**KIRKLEES METROPOLITAN COUNCIL
INVESTMENT & REGENERATION SERVICE**

**DELEGATED DECISION TO DETERMINE APPLICATIONS FOR
CONSENT, AGREEMENT OR APPROVAL REQUIRED BY CONDITION**

Reference No:	2024/44/90245/W
Site Address:	adj, 84, Dalton Green Lane, Dalton, Huddersfield, HD5 9UQ
Description:	Discharge conditions 5 (Construction Management Plan), 6 (visibility splays), 7 (parking spaces), 8 (materials), 9 (boundary treatment), 10 (floor levels), 11 (biodiversity enhancement), 12 (doors and windows) on previous permission 2021/94645 for erection of detached dwelling with parking and division of existing garden to provide amenity, parking and bin storage
Recommending Officer:	Lucy Taylor

Officer Report – Discharge of Conditions Application

Drawing title  
**Proposed Landscaping**

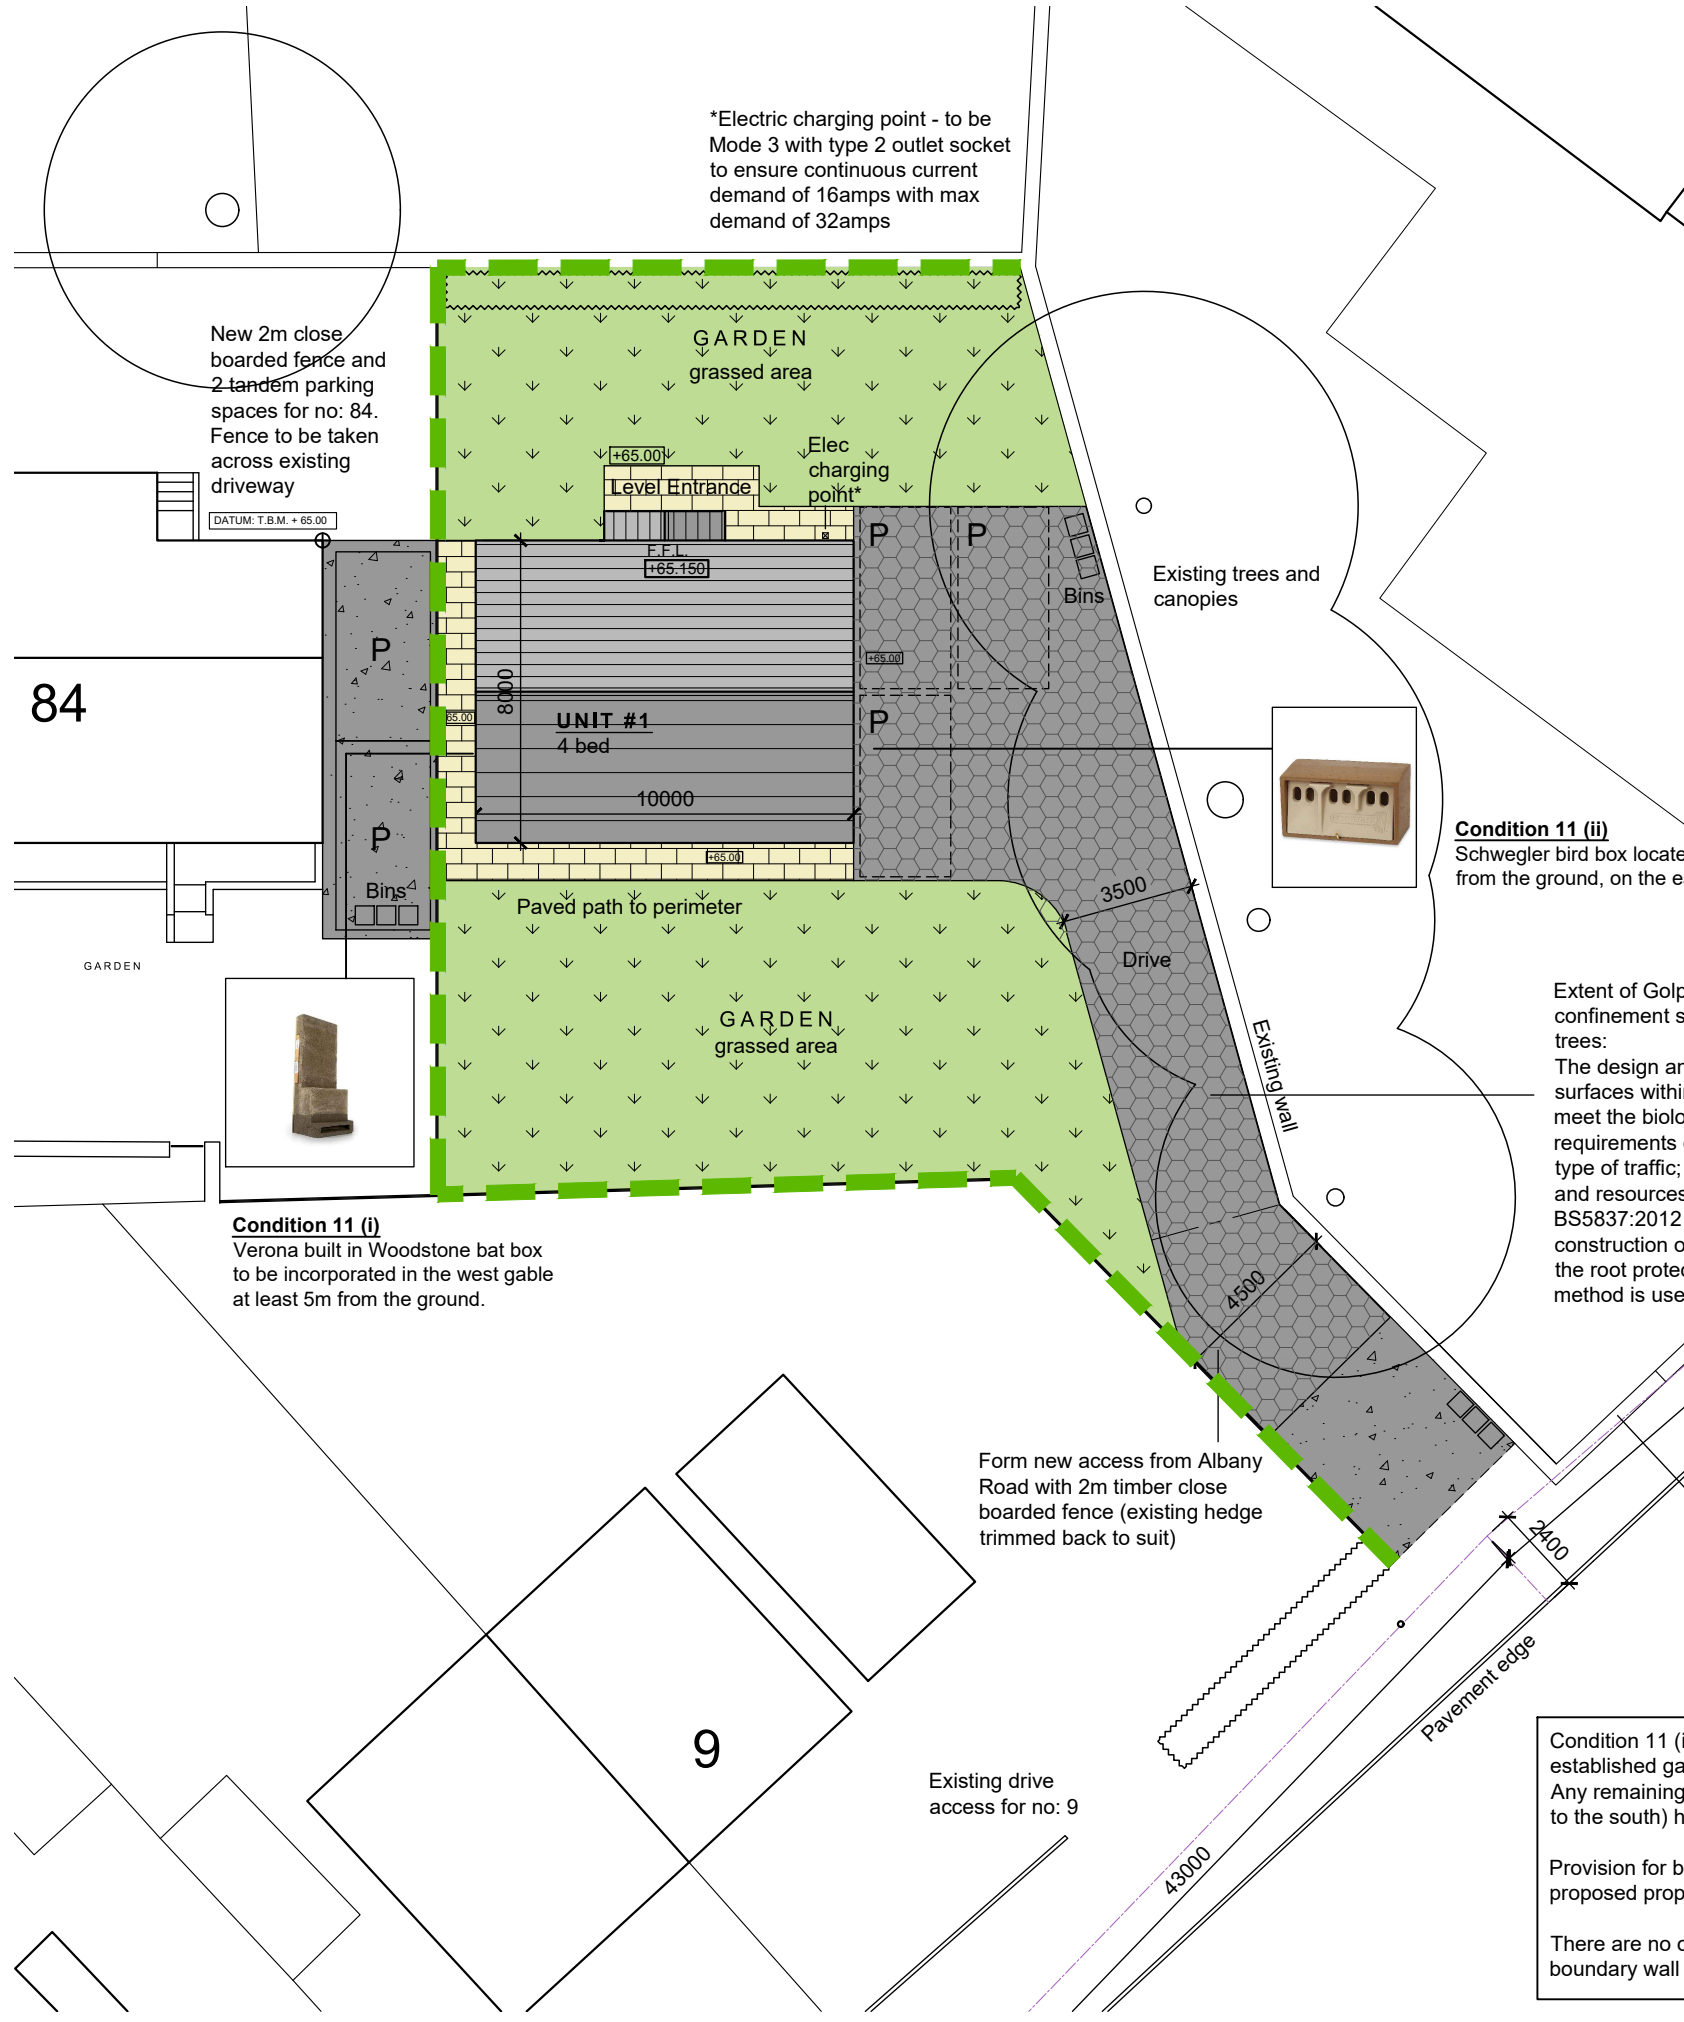
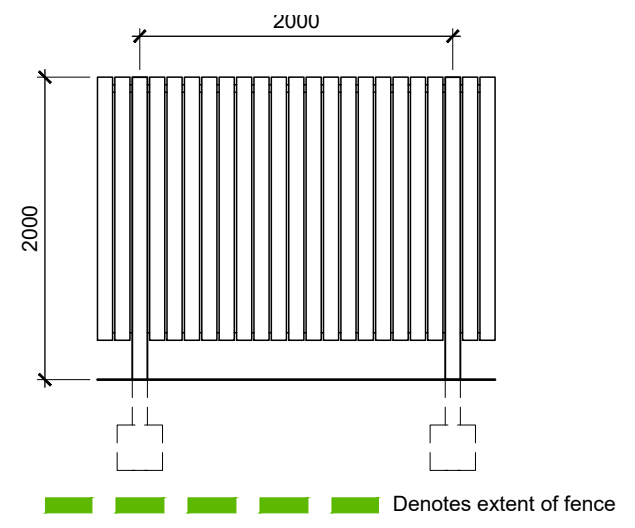
The submitted details are not considered to fulfil the requirements of condition 9 of planning application 2021/94645. Specifically, the submitted details do not annotate any fencing along the northern boundary of the site, between the proposed dwelling and No. 18 Higson Court. The submitted plan annotates boundary fencing along the shared boundaries between the new dwelling and 9 Albany Road and No. 84 Dalton Green Lane.

The finished floor level annotated on Drawing No. AL 05 Rev A shows 'F.F.L +65.150'.

Upon formal consultation with KC Ecology, the Council's Ecology Officer concluded that the submitted information is not sufficient to support the discharge of condition 11. Submitted details should include the specification of the faunal provisions that are to be incorporated into the proposals (E.g. Verona Built-in Woodstone Bat Box or suitable alternative). Until this information has been received, the discharge of condition 11 cannot be supported.

The Proposed Landscaping Plan (Drawing No. AL 05 Rev A) shows details of the proposed parking spaces and bin storage for No. 84 Dalton Green Lane and the photographs provided within report Rev A 01.02.24 show the formation of this parking area and the works to the gable wall of No. 84 which are in accordance with planning permission 2021/94645, showing the windows on the side elevation of No. 84 Dalton Green Lane to be infilled.

Therefore, based on this assessment, at this time, the Local Planning Authority are unable to discharge condition 9 of planning application 2021/94645. Should you wish to submit the further information in relation to the above, please do so within 21 days under this current application number (2024/90245) and no further fee will be required.

The submitted details are accepted to provide appropriate details of finished floor levels. Therefore, provided that the construction of the dwelling be thereafter carried out in accordance with the details so as approved before the dwelling is first occupied and retain condition 10 would be satisfied.

Therefore, based on this assessment, it is considered that the submitted details provide sufficient detail to allow the discharge of condition 12, provided that the details be retained thereafter.
